Job No. 186431

Re: Response to CGS and County Comments
8330 Mustang Pl
Lot 10, Pawnee Rancheros, Filing No. 2
El Paso County, Colorado

SHEET No. FIG-6

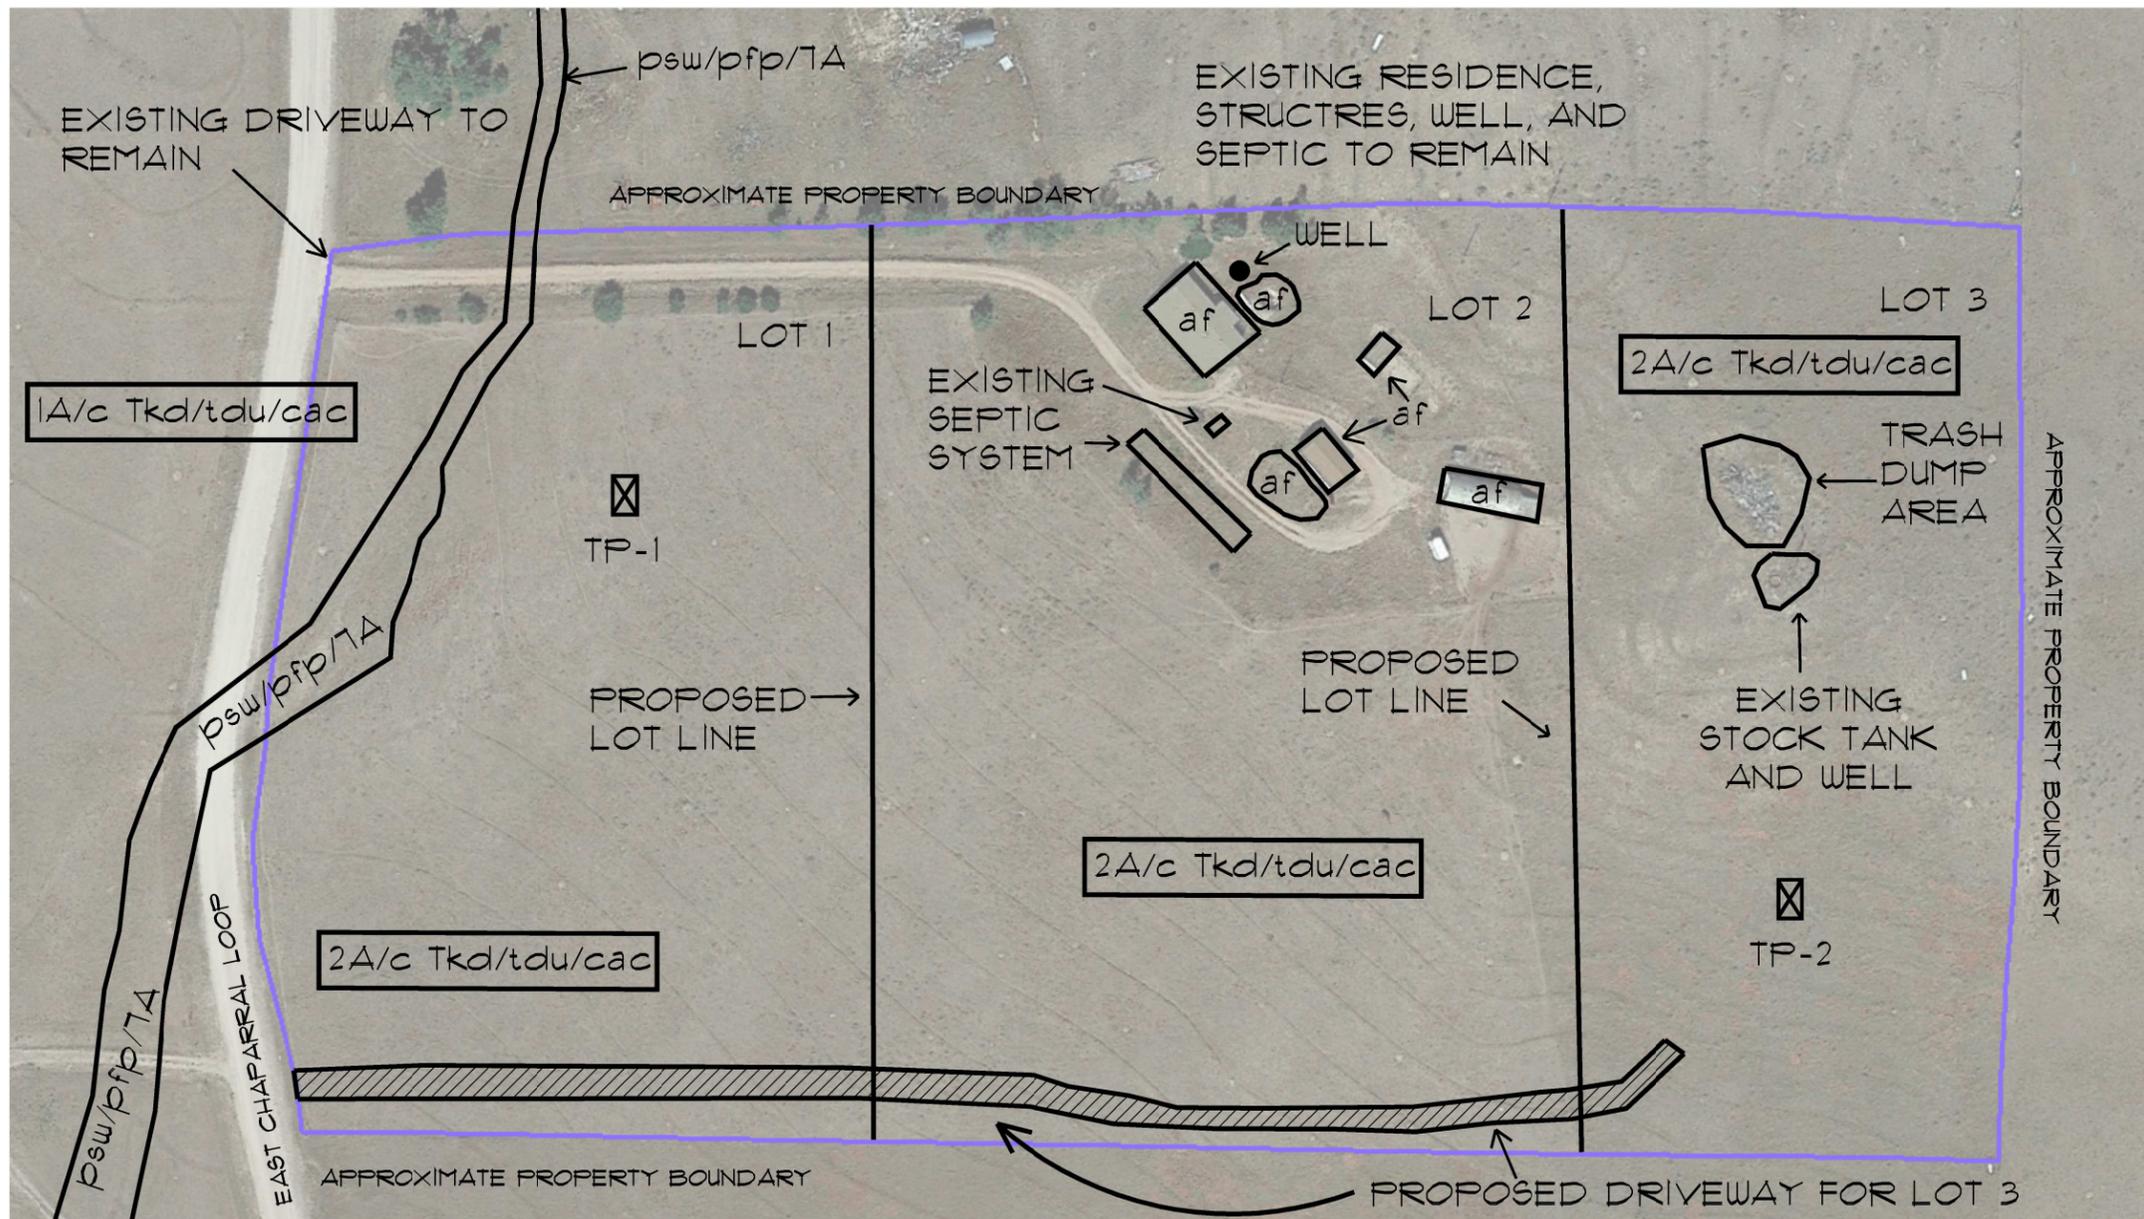
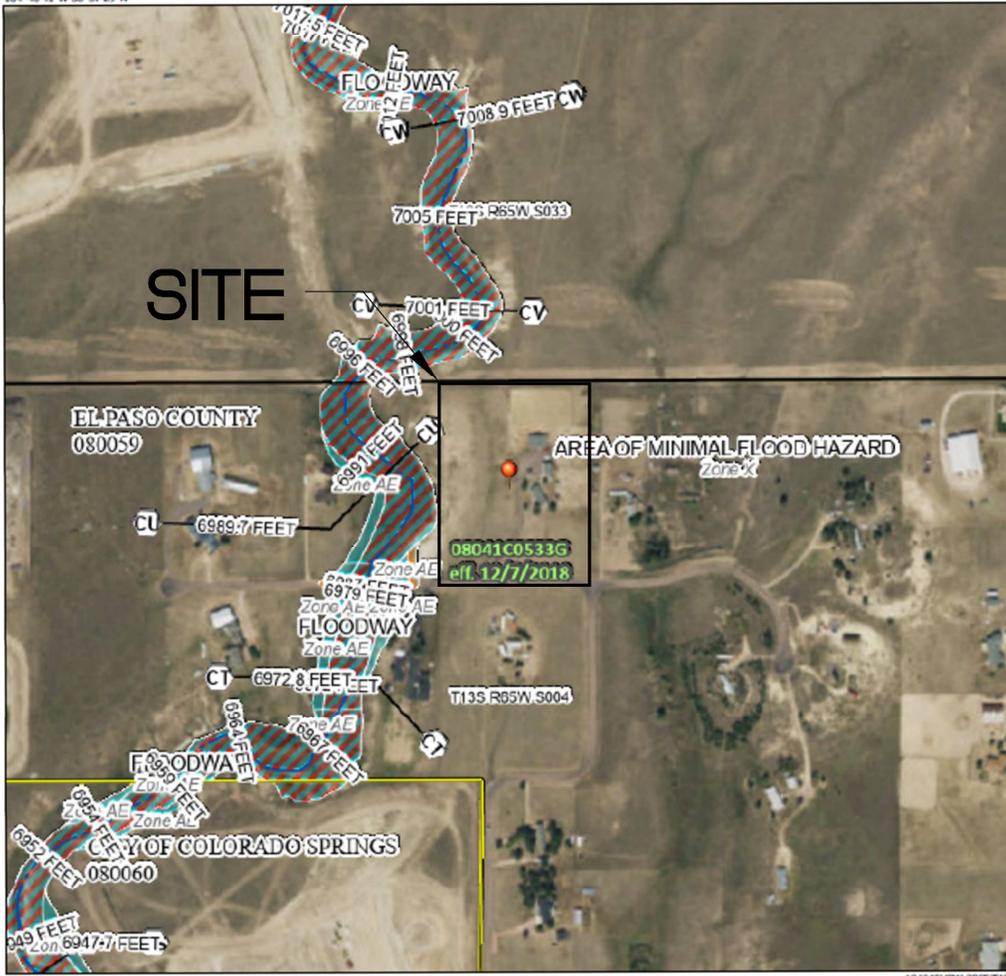
On the soils & geology report and OWTS report, one of the exhibits in the report is for the property on East Chaparral Loop. Please revise.

Regarding the exhibit in the report referencing the East Chaparral Loop property, the correct 8330 Mustang Place Engineering and Geology Map, Figure 6 is now included in the revised Soil, Geology, and Wastewater Study.

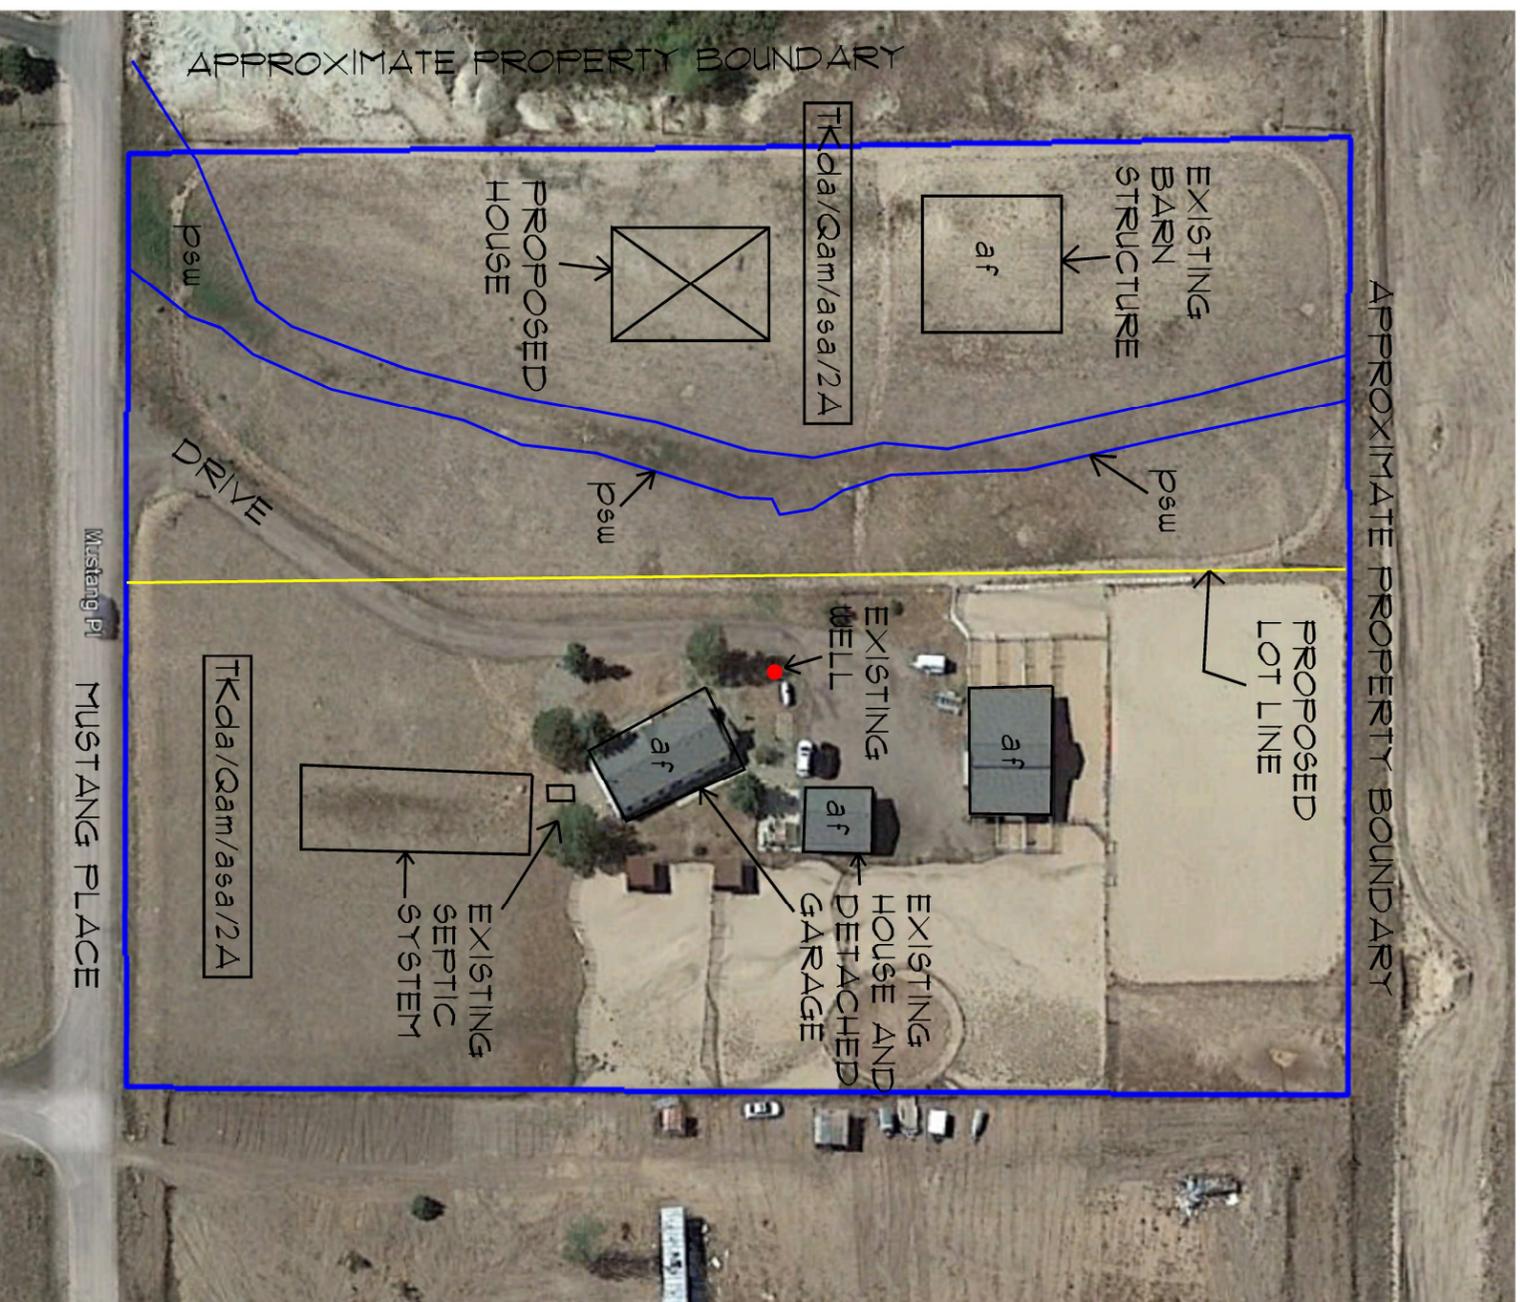
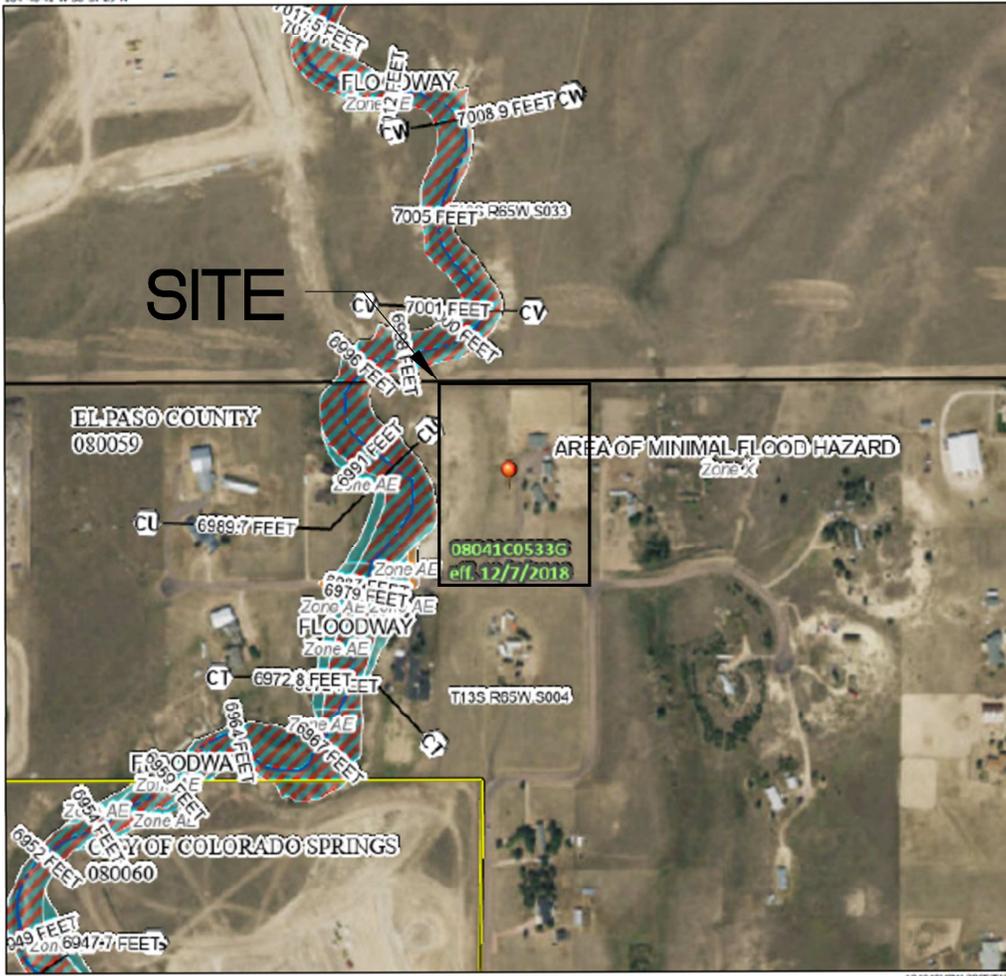
groundwater on the shallow bedrock. There may also be erosion hazards to the sandy soils that also may be susceptible to scour erosion associated with the Physiographic Floodplain depicted in RMG's Figure 6. This potential for scour erosion should be evaluated by the Civil Engineer for this lot (Lot 1 in Figure 6) to help determine the locations of residential or other types of structures.

Our report has been updated to include "other subsurface geologic conditions that are known in this general area that can impose hazards or constraints to residential construction at this location."

Sections in our report addressing specific "subsurface geologic conditions" can be found in Section 8.0, Identification and Mitigation of Potential Geologic Conditions.
